**KIRKLEES METROPOLITAN COUNCIL
INVESTMENT & REGENERATION SERVICE**

DELEGATED DECISION TO DETERMINE PLANNING APPLICATIONS

Reference No:	2025/62/93092/W
Site Address:	14, Bridge View, Fixby, Huddersfield, HD2 2GS
Description:	Erection of first floor front extension
Recommending Officer:	Joshua Merriman

Officer Report – 2025/93092

Date Issue Date	Project number Project Number	Scale (@ A3) 1 : 200
Drawn by bl	DRAWING NUMBER P10	REV

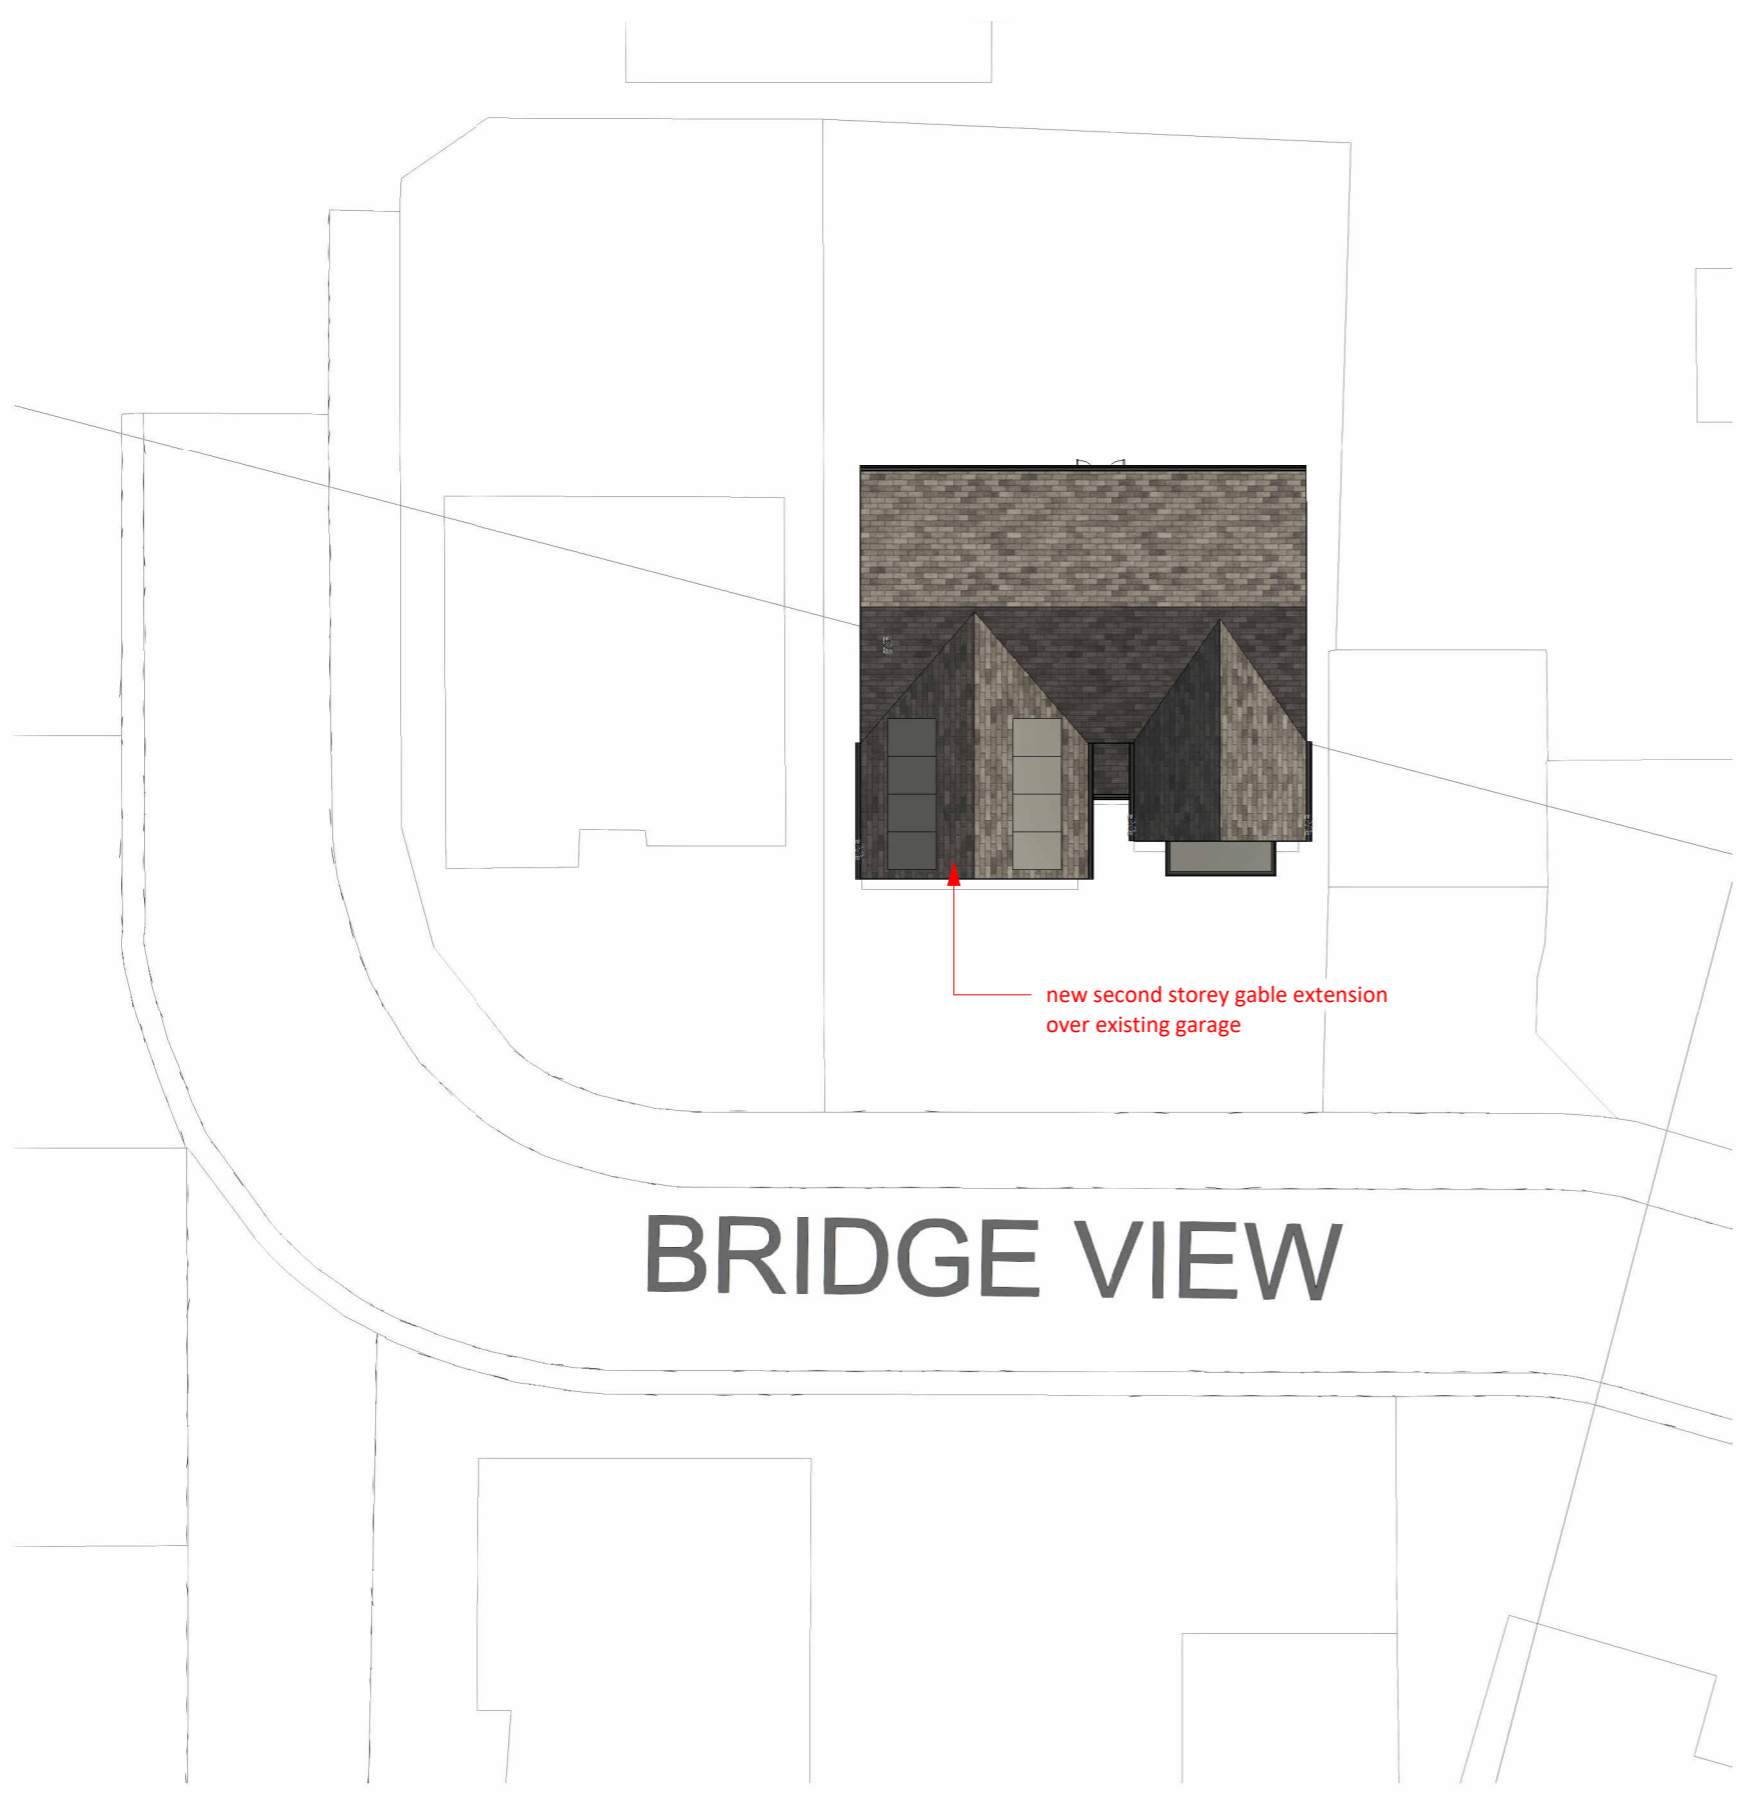
The development proposes red brick and a tiled roof to match the existing building. Furthermore, the dwelling, and extension, are set well back from the pavement and the proposal is considered to be subservient to the existing dwelling.

The development will have no significant impact on highway safety as the dwelling is set well back from the closest highway.

Date Issue Date	Project number Project Number	Scale (@ A3) 1 : 100
Drawn by Author	DRAWING NUMBER P11	REV

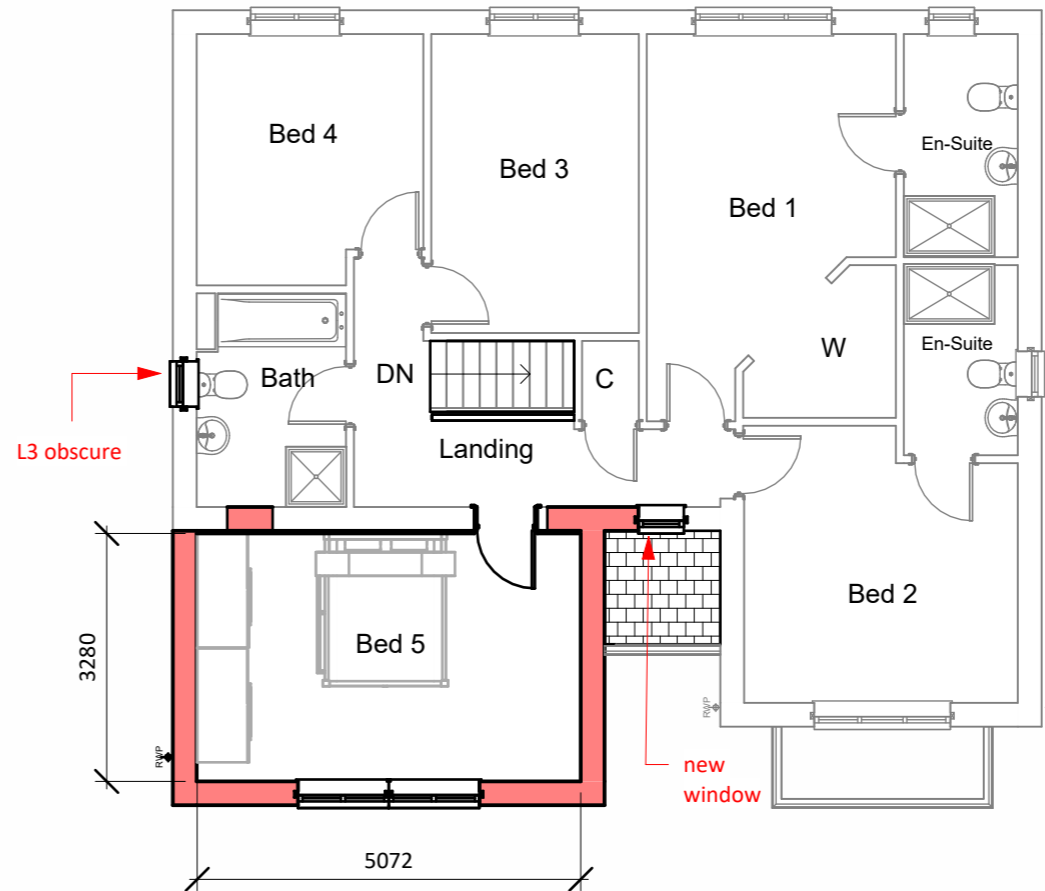
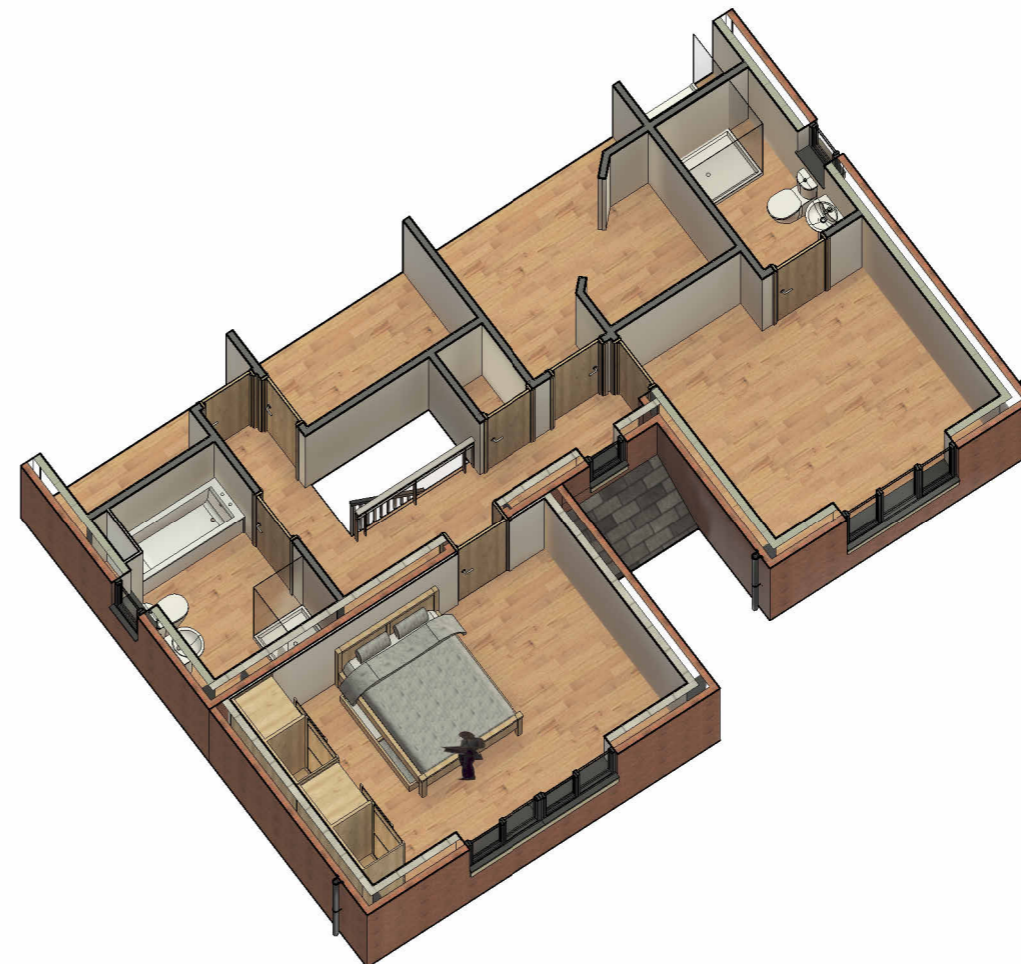
The plans show a new window in the first-floor side elevation of the existing dwelling. This is depicted to serve a bathroom and will be obscurely glazed. There are no windows in the opposite elevation of the neighbouring dwellings, and as such there will be no loss of amenity to neighbouring occupants.

The number of bedrooms in the property will increase from four to five as a result of the development, and the number of off-street parking spaces required on site will not change. The current parking provision is considered acceptable for the development proposed.

Date Issue Date	Project number Project Number	Scale (@ A3) 1 : 100
Drawn by bl	DRAWING NUMBER P12	REV

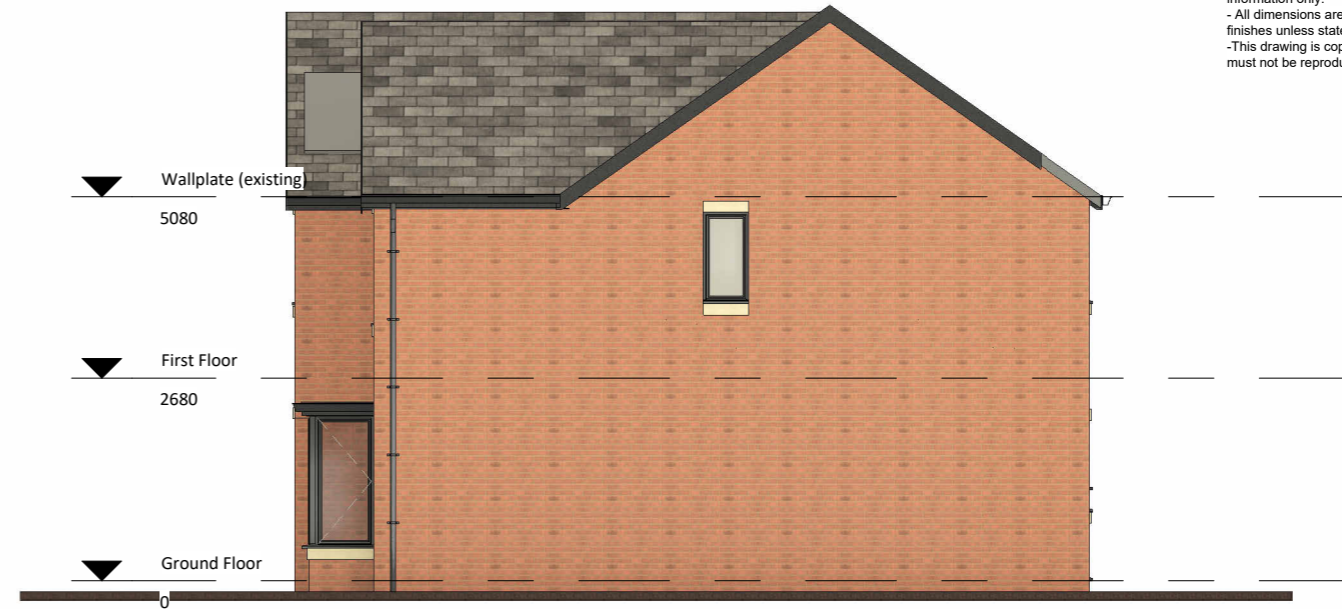
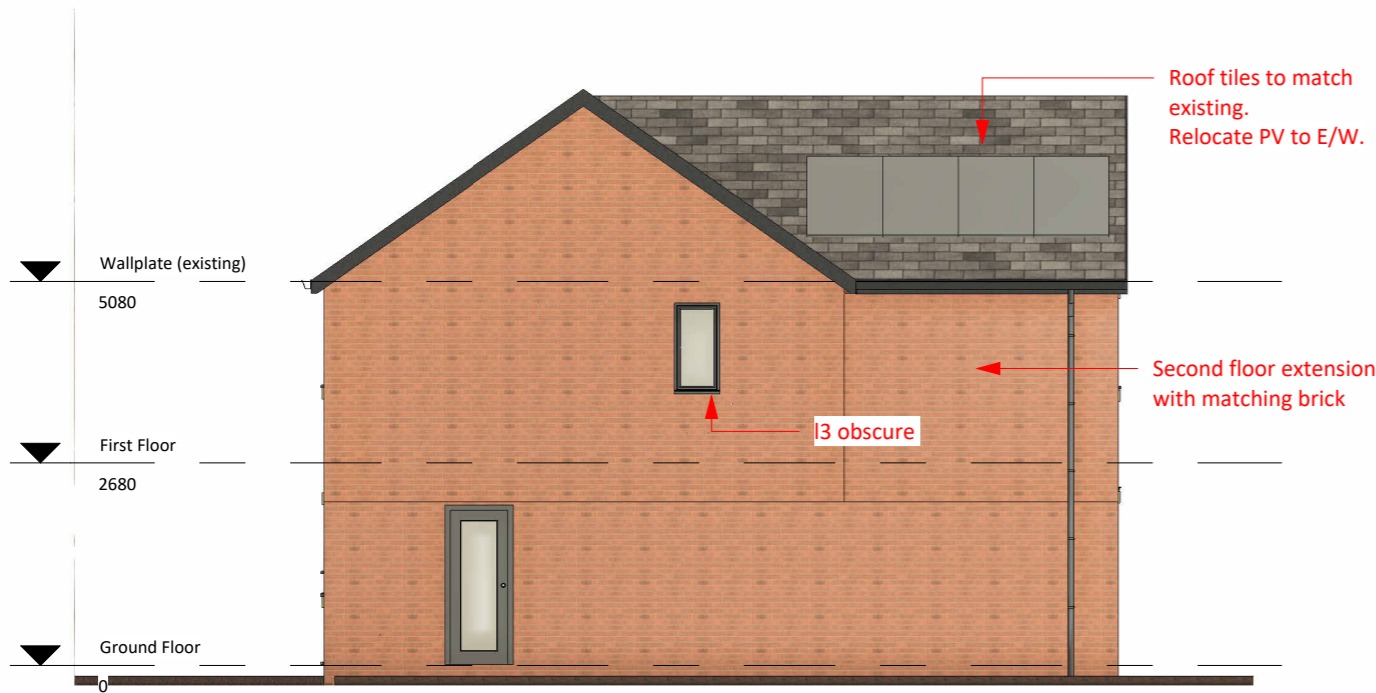
The first floor front extension sits over an existing garage and will project 1.05m from the frontmost elevation of the existing building, with a maximum height of 7.73m, eaves height of 5.07m, and a width of 5.67m.

It is noted there is the addition of a first-floor window in the side gable of the existing dwelling. It is not clear if this is being applied for as part of this scheme, but will be assessed in the relevant sections of this report.

The first-floor side window is a new addition to the application property and is similar in details to the existing windows in the dwelling. It is not considered to detract from the character of the host property and is therefore acceptable.

As there are no openings in the side elevation of the extension, and the windows in the front elevation are not considered to have any greater impact than existing windows in the front elevation, there will be no material impact with regard to overlooking or privacy. Furthermore, due to the adequate distance between the proposal and neighbouring property to the west, it is considered that there will be no significant impact upon overshadowing, overbearing, light, or outlook on neighbouring properties.
